Application No: BN/42/21/PL
Site Address: Folly Foot Farm Fontwell Avenue Eastergate PO20 3RU
Description of works: Demolition of existing dwelling, garage & commercial buildings & erection of replacement dwelling, garage & commercial building (Use Class B1 (E) B8) with associated vehicular accesses from Eastergate Lane & hard and soft landscaping. This site is in CIL Zone HSP2 (Zero Rated) & is a Departure from the Development Plan.

Thank you for your internet representation made on 4th June 2021 which has been recorded as an objection with the comments as follows:

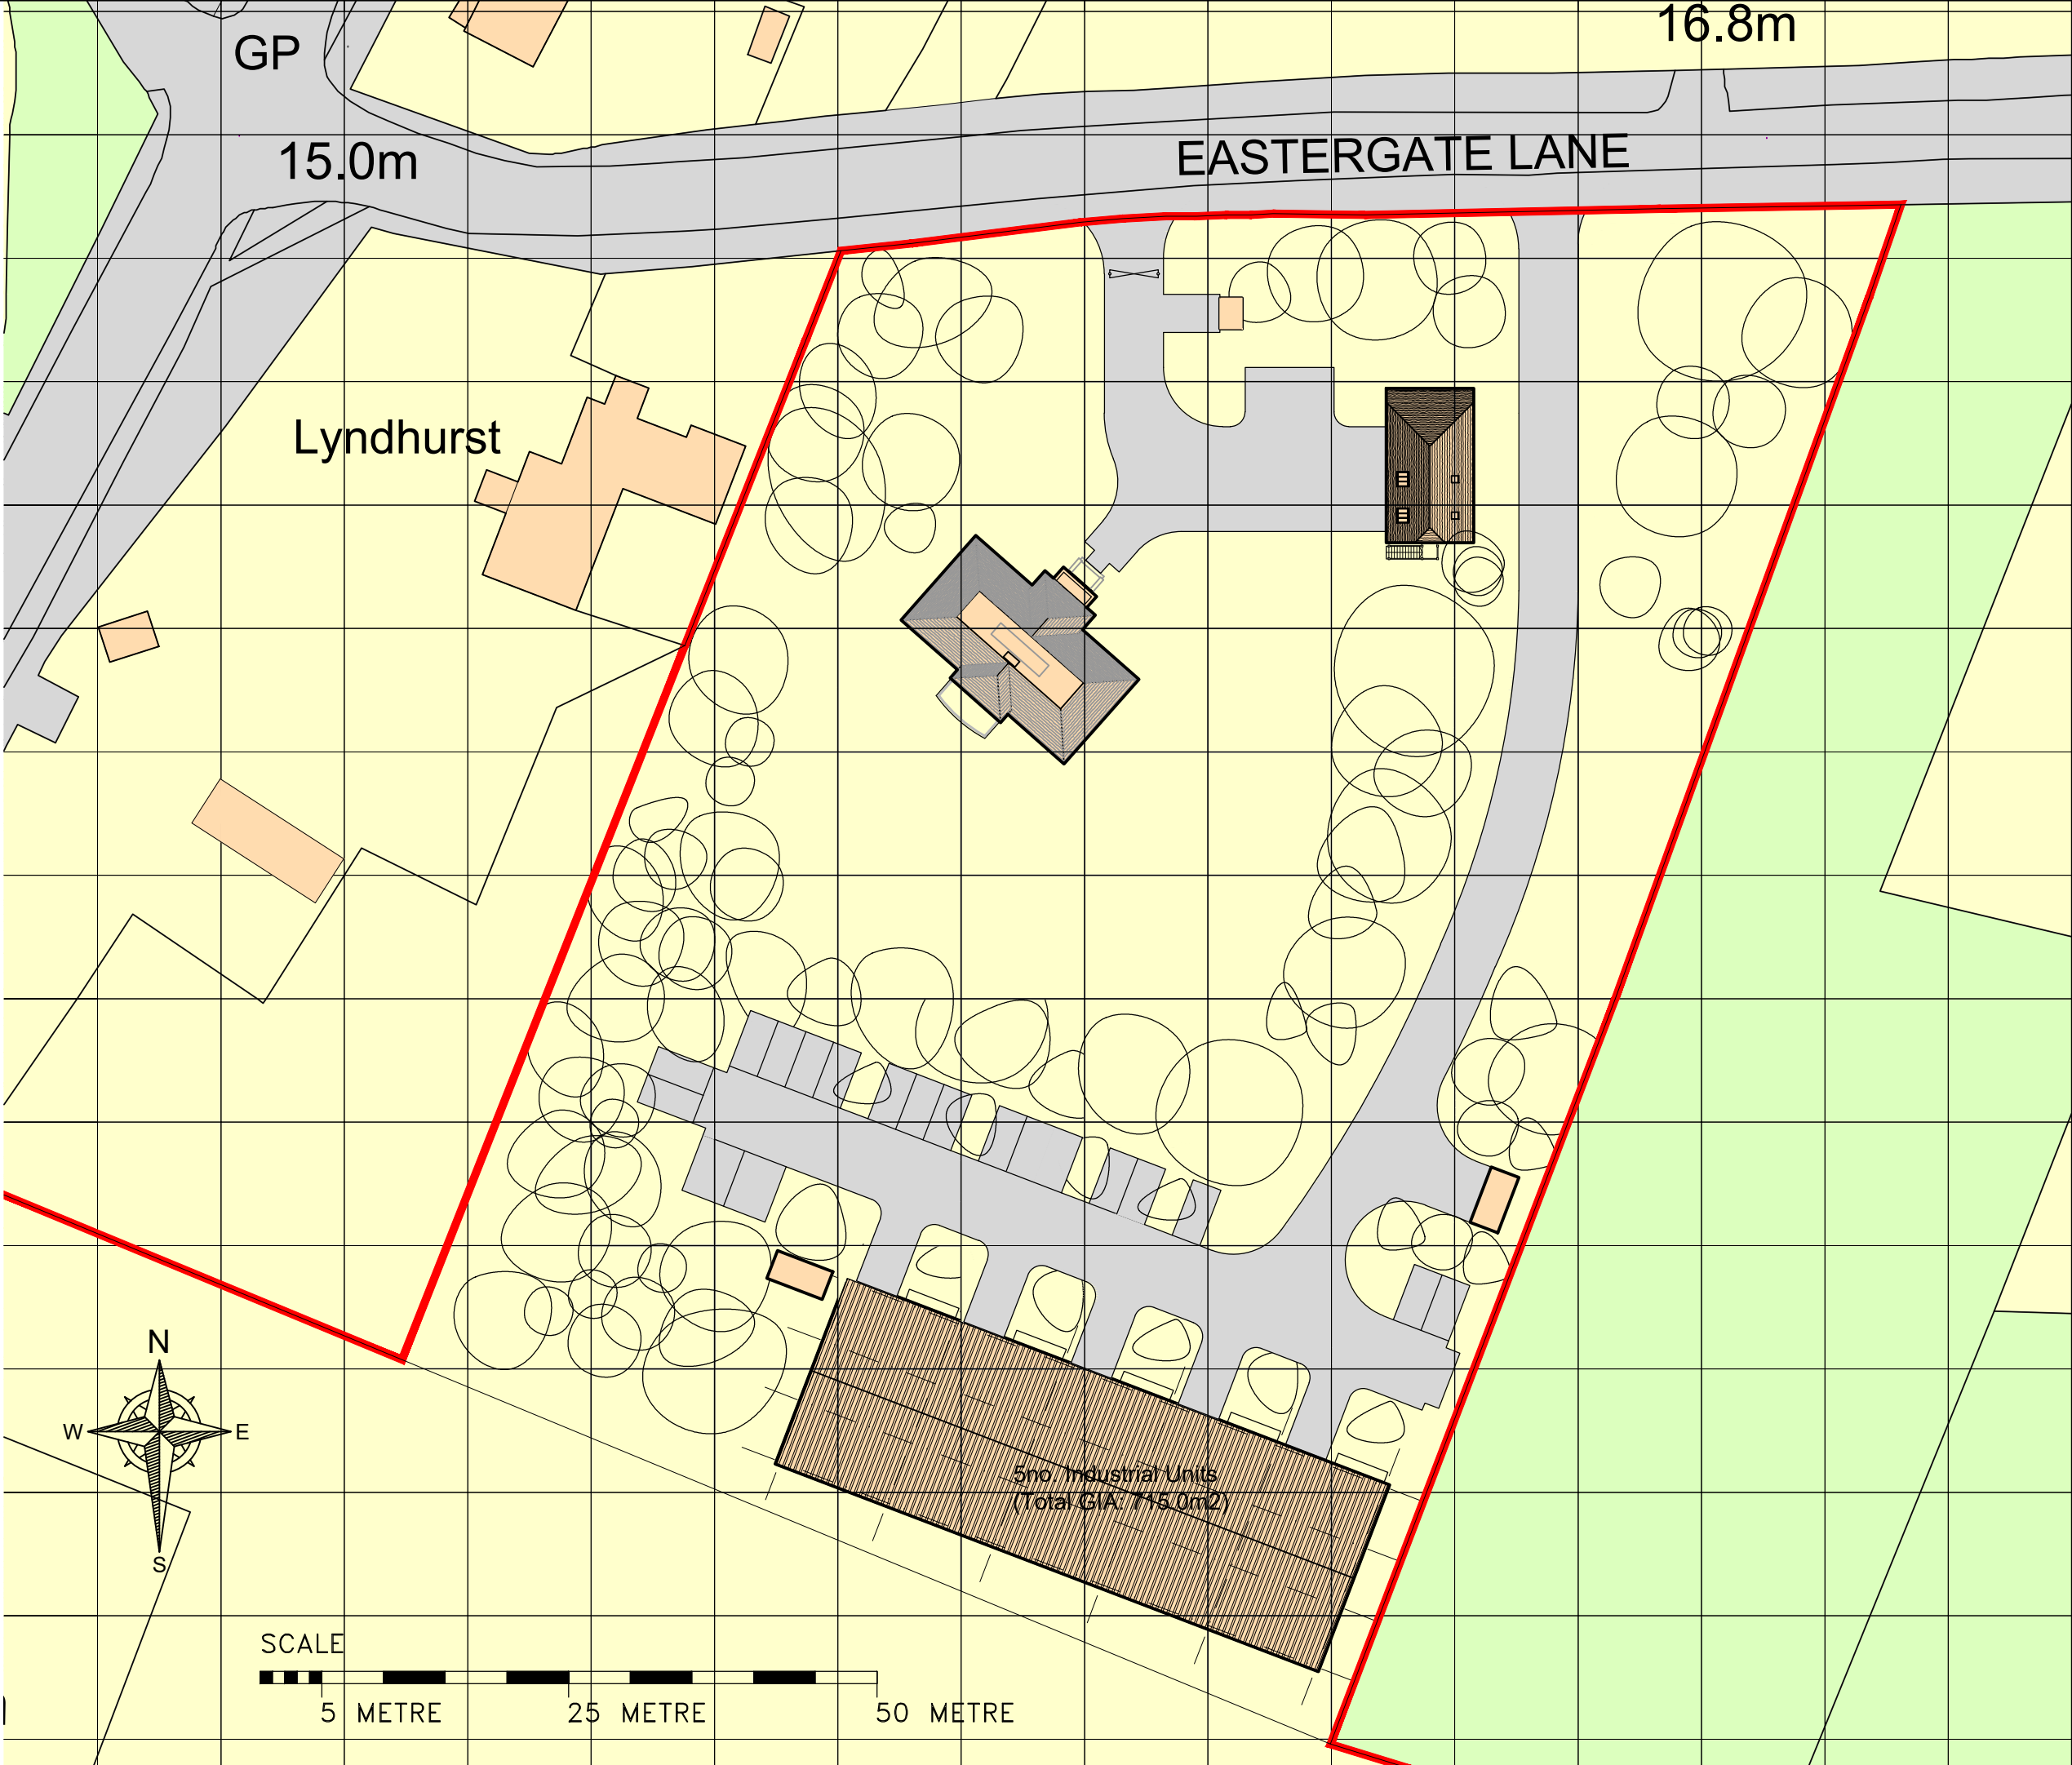
I have no issue with the plan for the house and it's access, I strongly object to the new entrance for the purposes of the commercial B8 business being on Eastergate Lane.

It would be far more appropriate - and safer - to have the business access from the SE corner of the site directly onto the new A29. The current business access is directly to the A29 so this would be consistent, a precedence has also been set with the re-designed access for Halo on Barnham Road, that is being made directly to the new A29.

It is wholly inappropriate to have this new business access on Eastergate Lane.

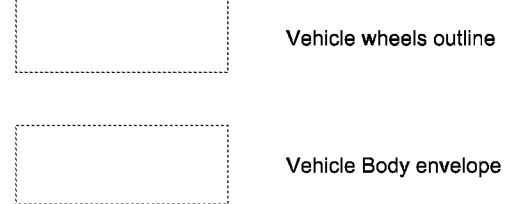
At 8m - 12m in length, these vehicles cannot safely turn from Fontwell Avenue into Eastergate Lane, they have inadequate visibility and invade the lane of traffic travelling West to that junction.

The vehicle tracking plan also shows how excessively large the vehicles are relative to the width of Eastergate Lane, and how vehicle movements to and from the site will require the use of both sides of the lane.
